re: Geotechnical Review of Grading and Servicing Plans
Proposed Residential Development
214 Somerset Street East - Ottawa, Ontario
to: Ottawa Community Housing Corporation – Dylan Bennett – Dylan_Bennett@och.ca
date: August 22, 2025
file: PG6626-MEMO.02 Revision 1

Grading Plan Review

Servicing Plan Review

Scale:	1:100	Project Number:	CCO-24-0450
Drawn By:	R.P.		
Checked By:	A.B.	Drawing Number:	C102
Designed By:	R.P.

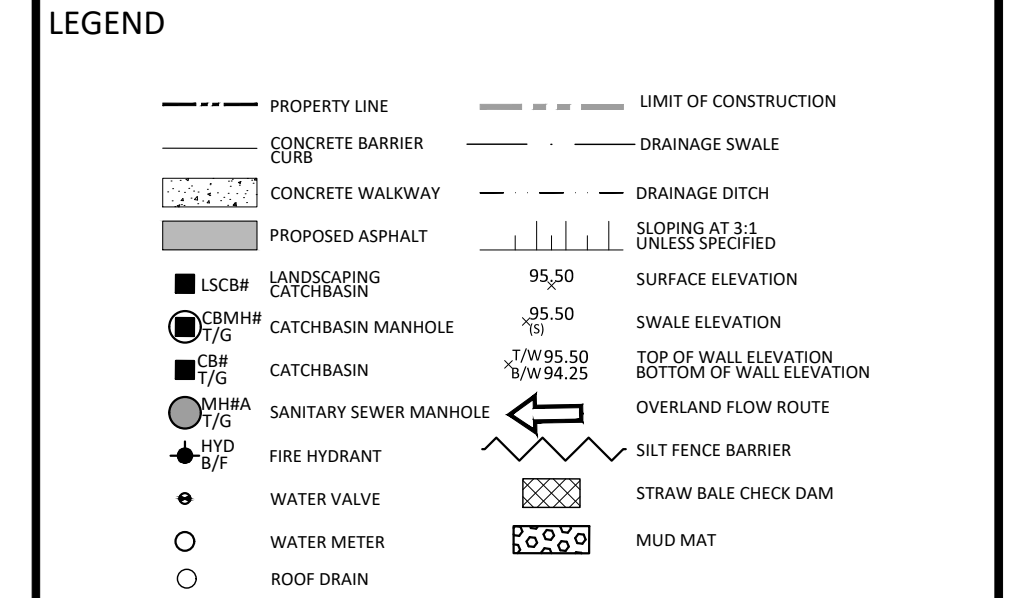
- ❑ Site Servicing Plan - Residential Building, 214 Somerset St. E. - Project No. CCO-24-0450 - Drawing No. C102 – Revision 10 dated August 22, 2025.

Based on our review of the above-noted drawing, the majority of the design details (i.e., lateral support of footings, adequate frost protection of services, pipe bedding and backfill, clay seals), provided by Paterson in the aforementioned geotechnical investigation report have been satisfactorily incorporated into the above-noted drawing.

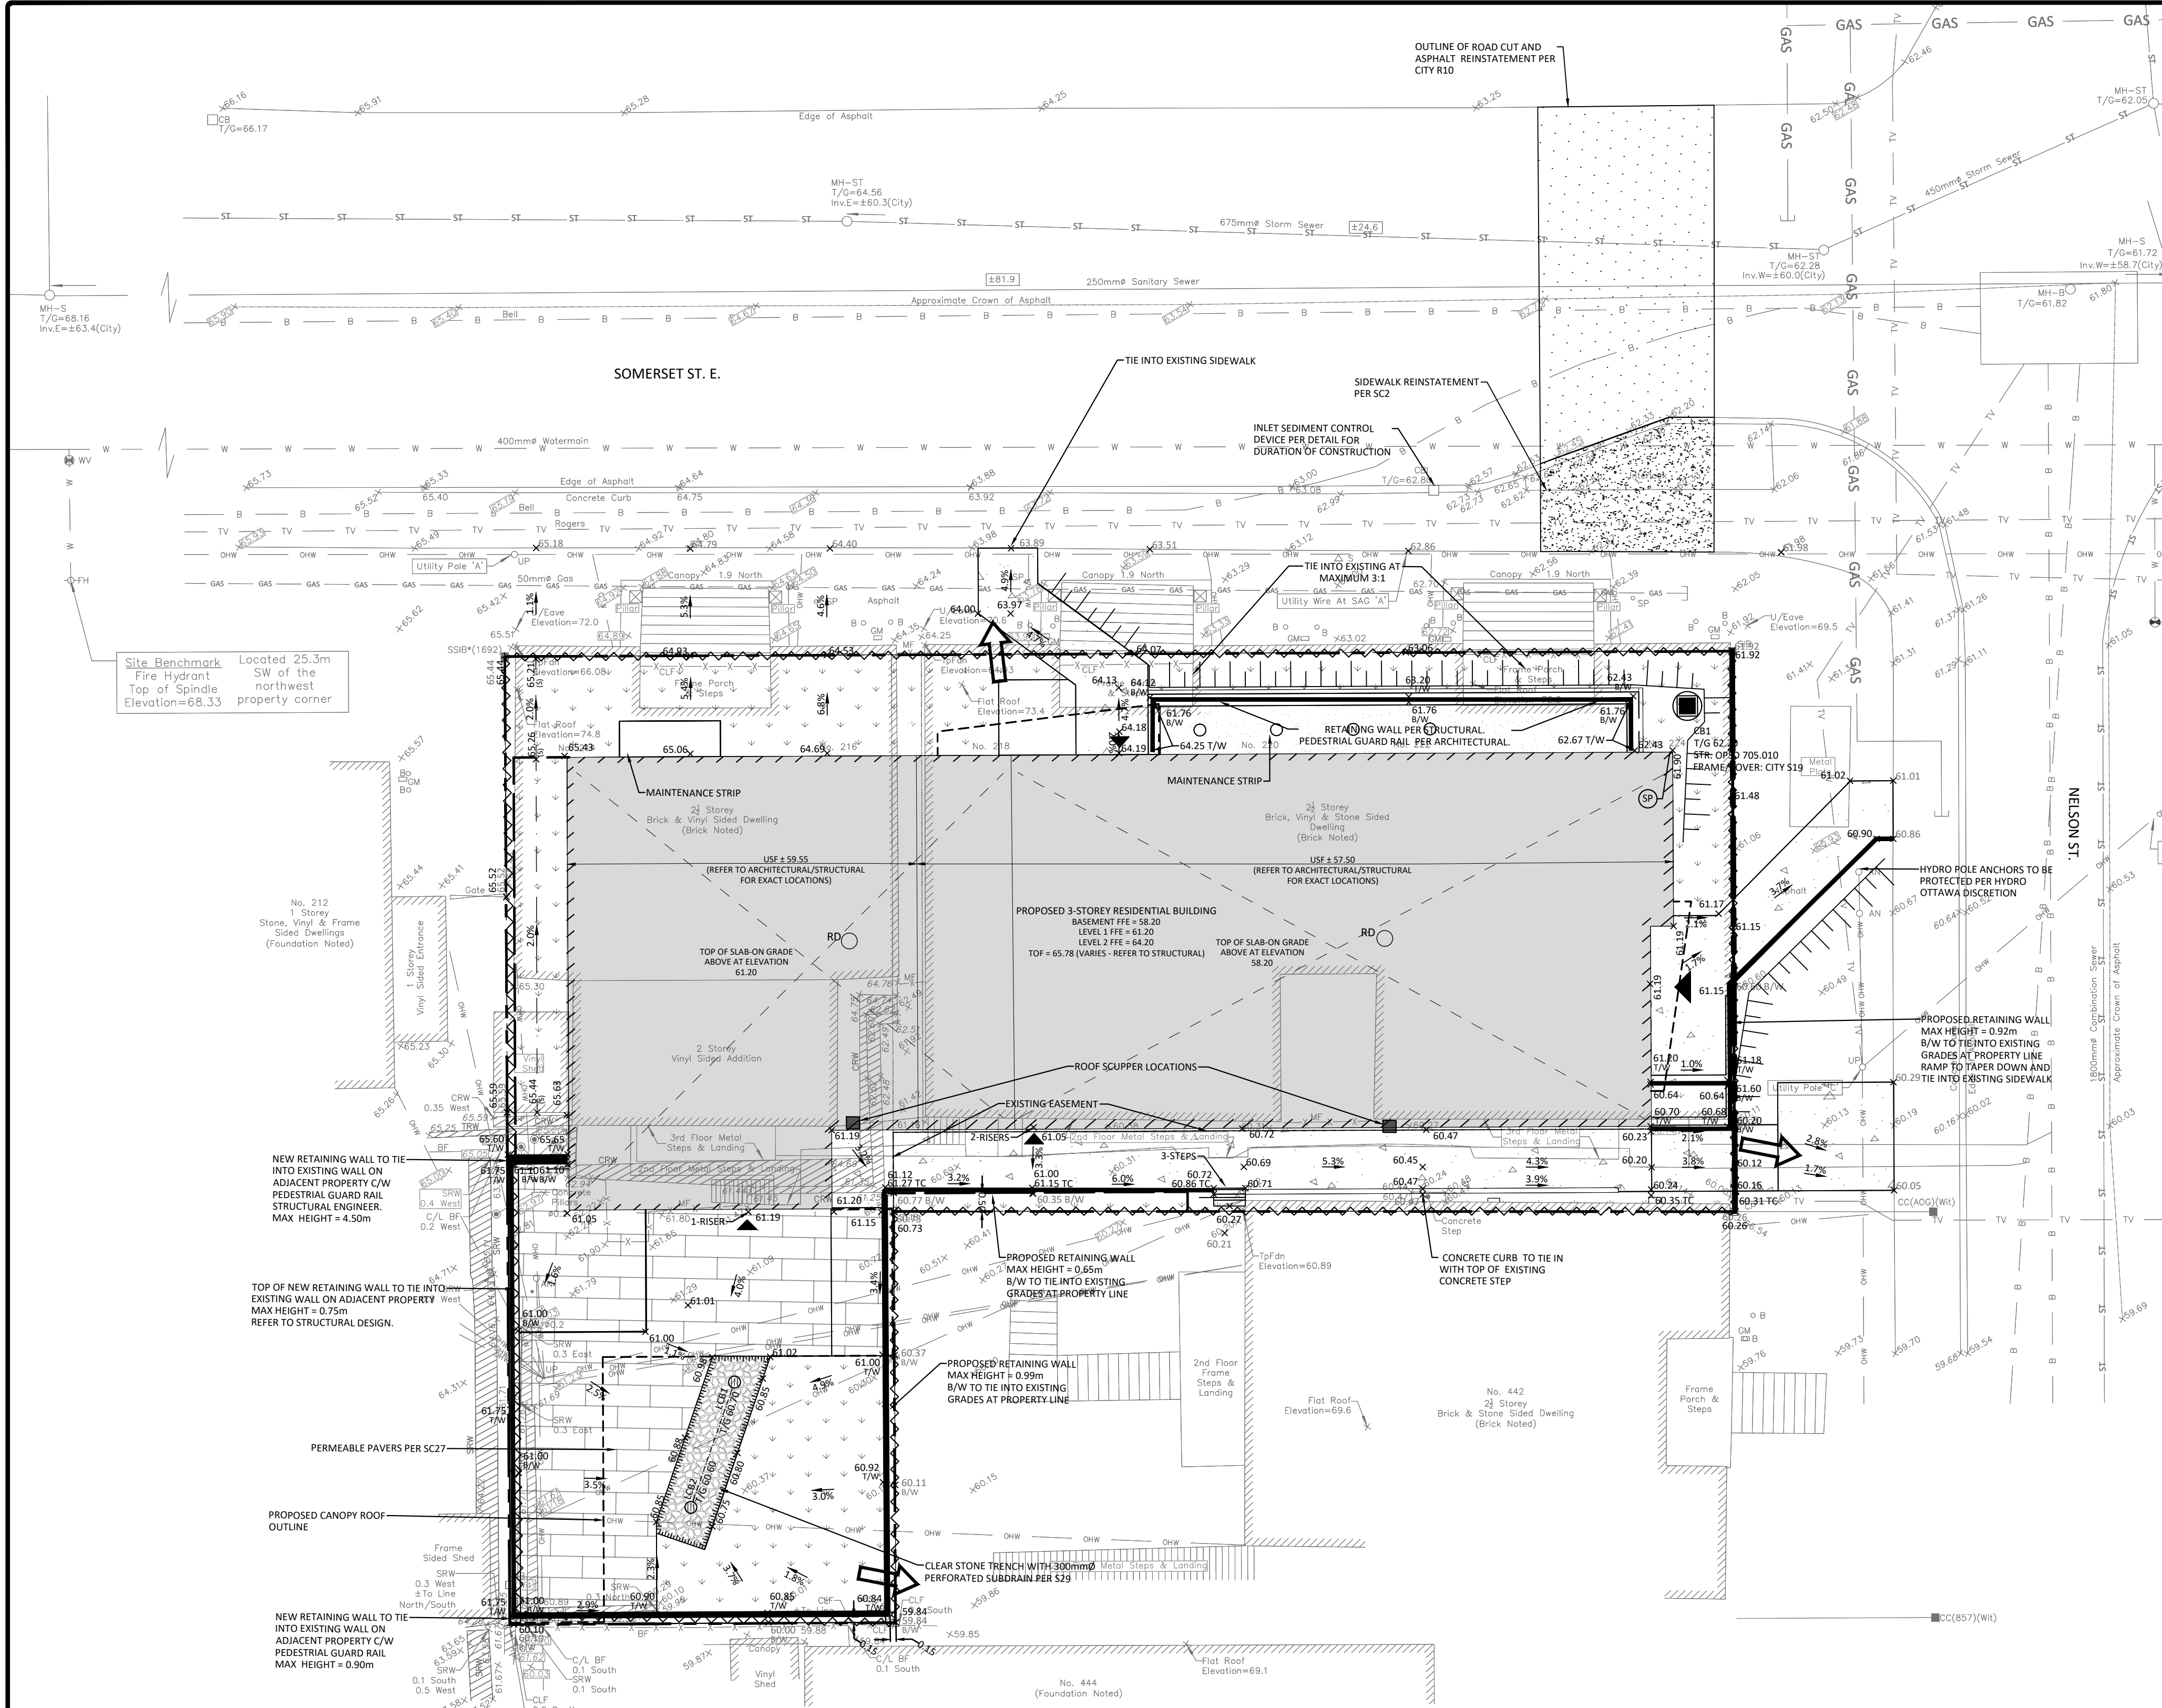
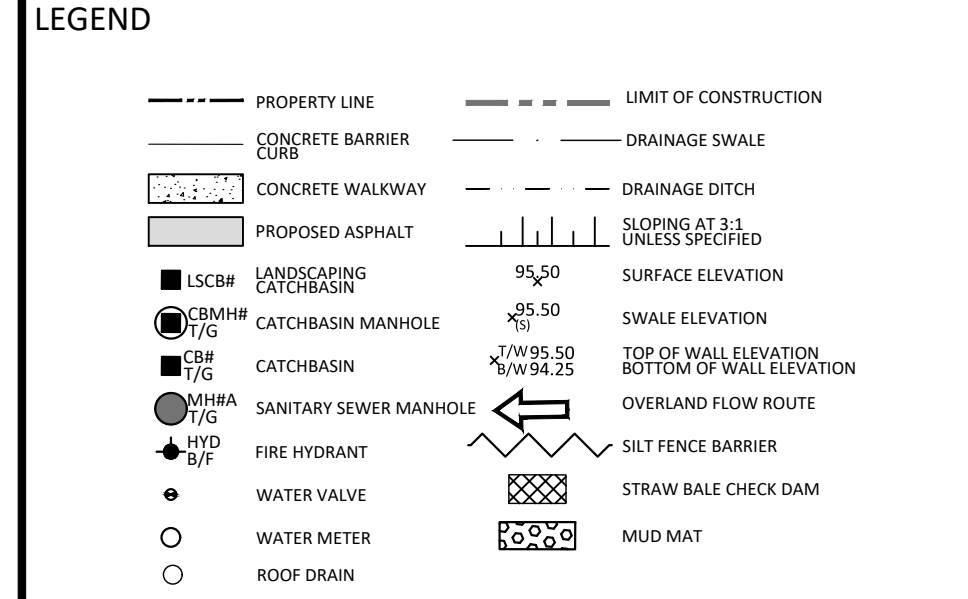
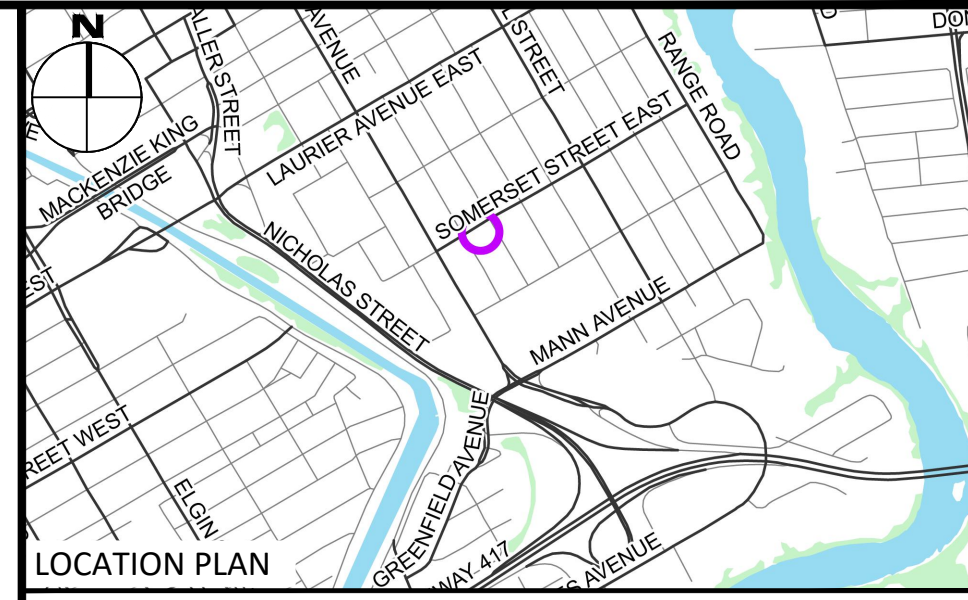
- ☐ Site Grading, Drainage and Erosion & Sediment Control Plan - Residential Building, 214 Somerset St. E. - Project No. CCO-24-0450 - Drawing No. C101 - Review 10, dated August 22, 2025.

Based on our review of the above-noted drawing, the proposed grades throughout the subject site are generally within the permissible grade raise restriction of 2 m provided in the aforementioned geotechnical investigation report. Therefore, the proposed grading is considered acceptable from a geotechnical perspective such that lightweight fill (LWF) or any further measures will not be required to be taken for the proposed development. Further, sufficient soil cover has been provided to perimeter and exterior pad footings such that the use of insulation to mitigate the migration of frost will not be required for the subject footings.

- ☐ The underside of footing (USF) is 2.1 m or greater below the lowest finished grade must be satisfied for footings within 10 m from the tree, as measured from the center of the tree trunk and verified by means of the Grading Plan. Based on Paterson's review, this condition is met.

- ☐ Grading surrounding the tree must promote drainage to the tree root zone (in such a manner as not to be detrimental to the tree), as noted on the subdivision Grading Plan.
